**From:** Richards, David [REDACTED]  
**Sent:** 28 September 2022 09:29  
**To:** DraxBECCS <DraxBECCS@planninginspectorate.gov.uk>  
**Subject:** Drax Power Station Bioenergy with Carbon Capture and Storage Extension Development Consent  
(our ref: 22/01017/CON)

Thank you for your letter dated 30 August requesting any observations from Doncaster Council on the acceptance of the Drax Power Station Bioenergy with Carbon Capture and Storage Extension DCO Application.

DRAWING TITLE
FIGURE 10.1 DESIGNATED HERITAGE CONSTRAINTS (KEY PLAN)

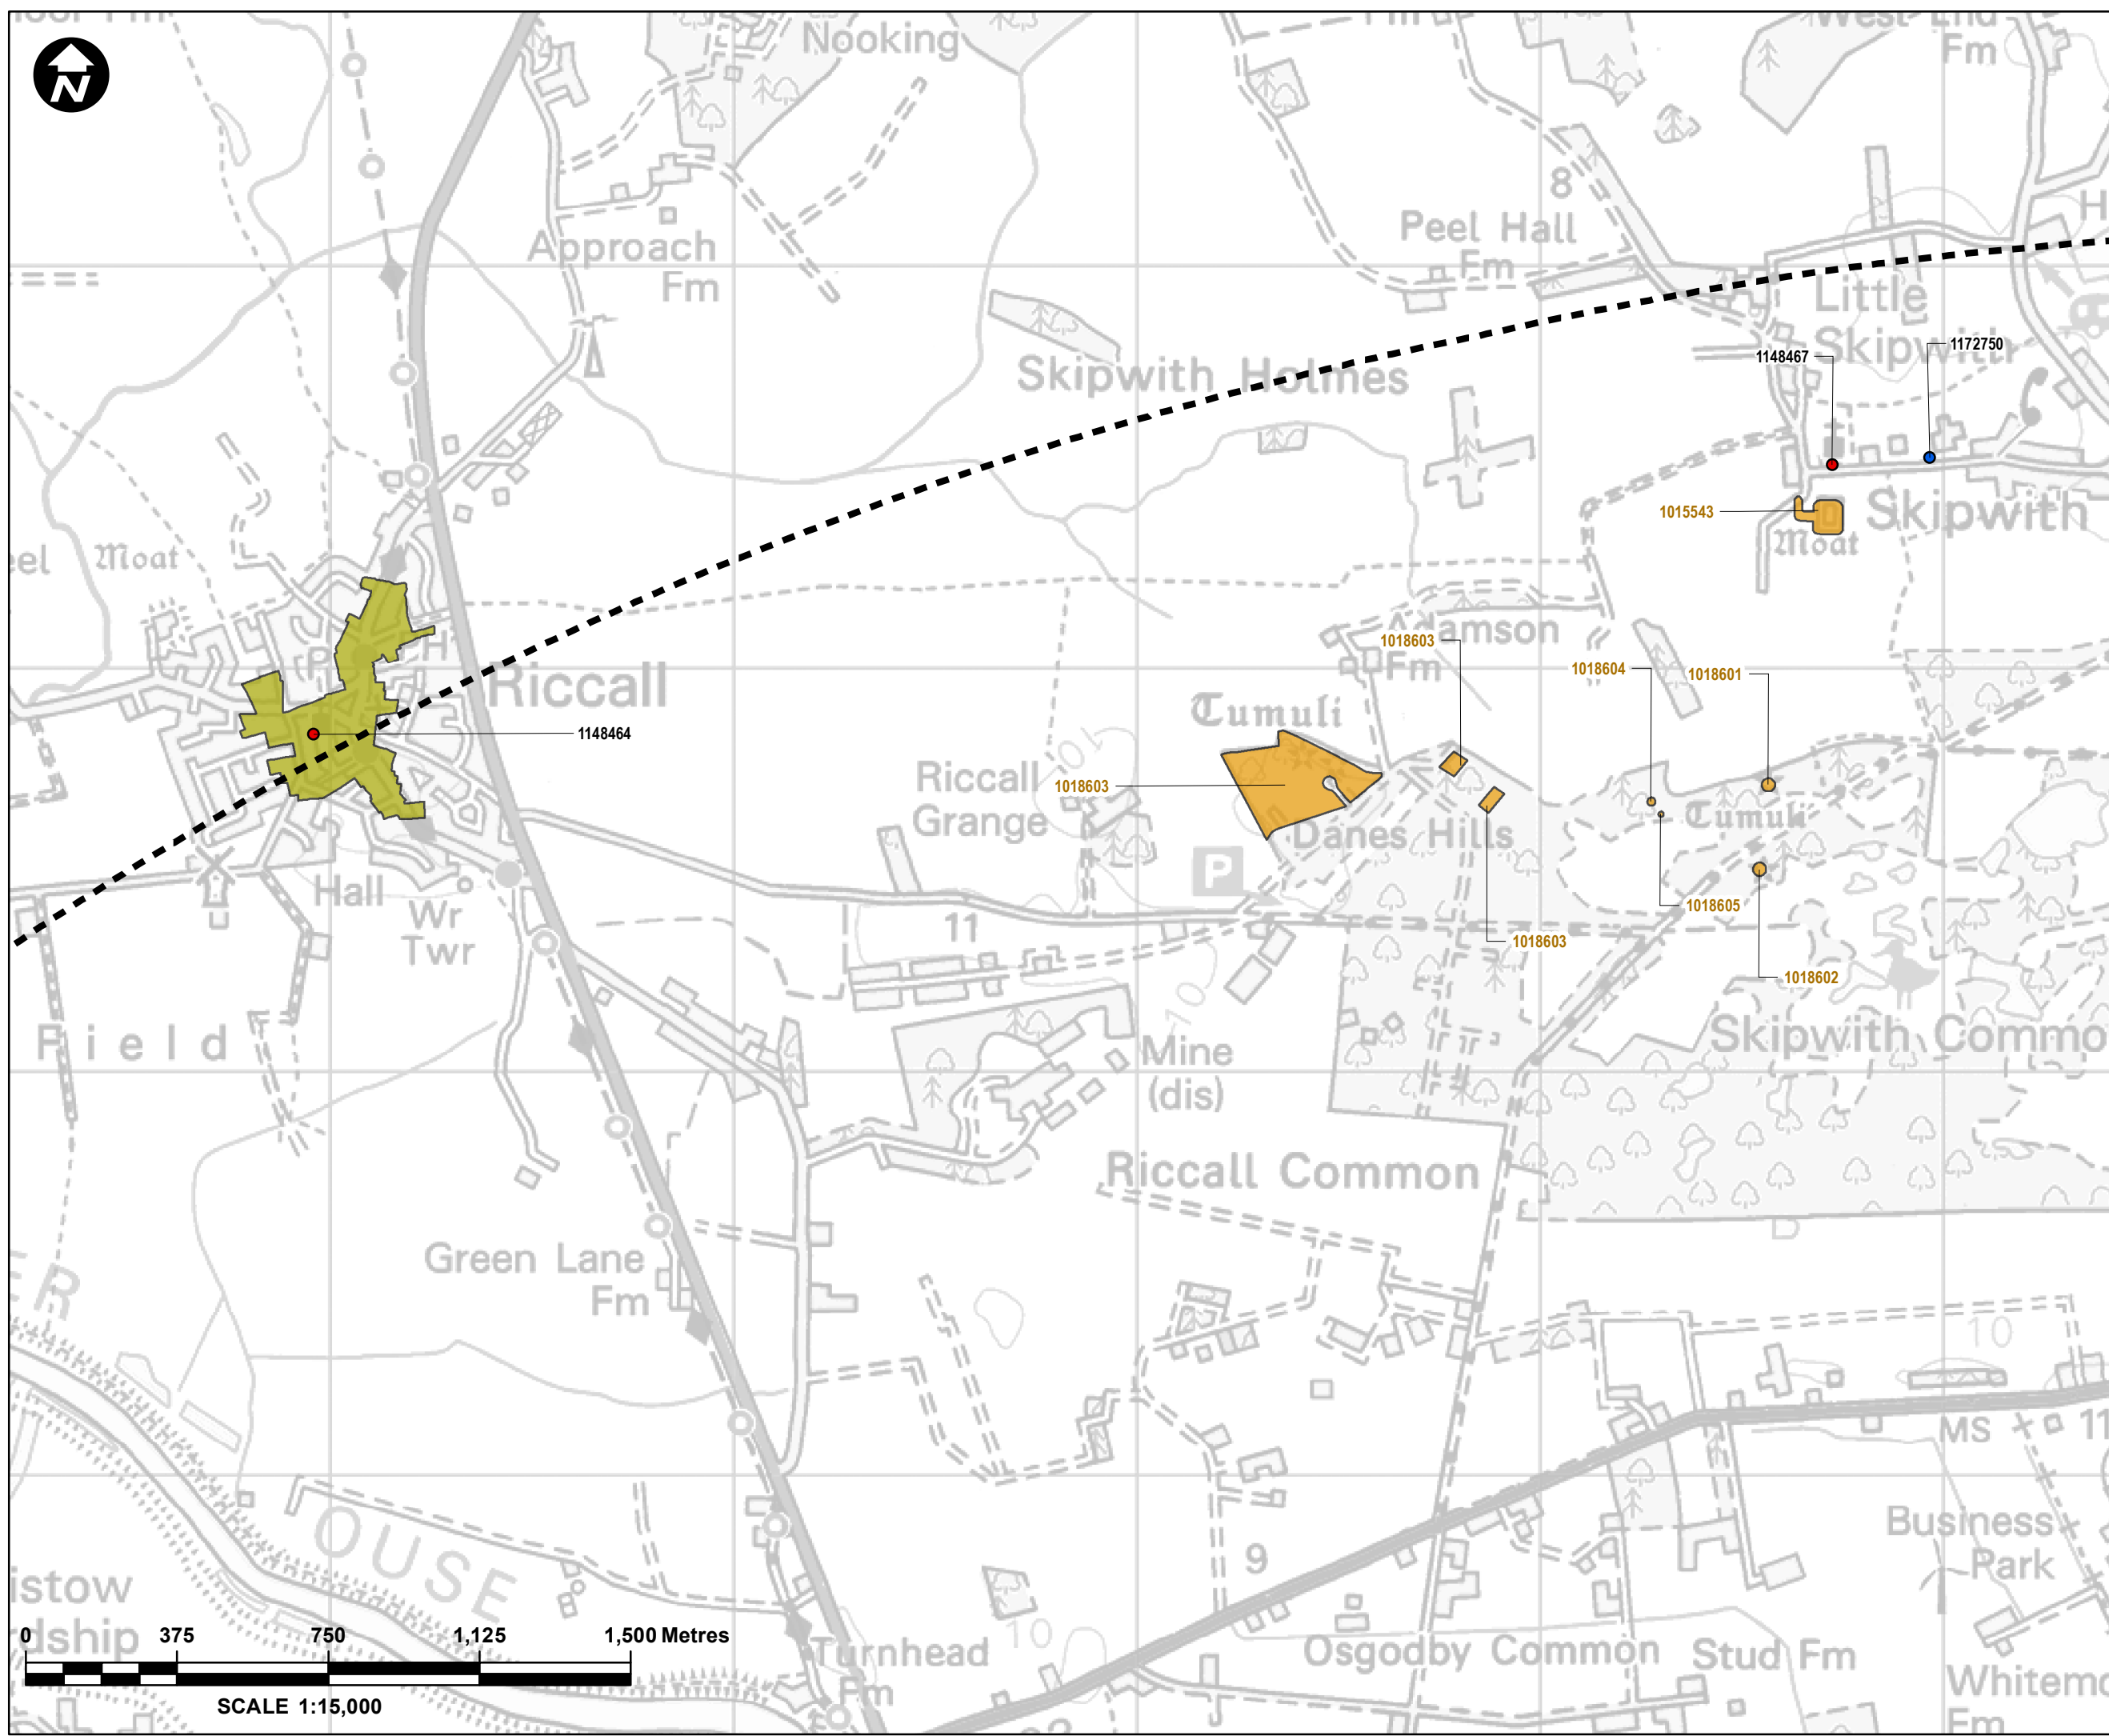
The EIA Scoping Report identifies a study area of 10km radius from the application site. This is a sufficient zone of influence to cover potential impacts on the setting of heritage assets and includes part of DMBC area along our northern boundary. Within this study area there is a Scheduled Monument and a small number of listed buildings (farmhouses) which can be identified through Historic England's list of heritage assets. It is unlikely that their settings will be affected but the methodology to be employed as described in 11.7 of the scoping report is sufficient. There are no conservation areas or identified undesignated heritage assets within the study area that would require further consideration not identified here.
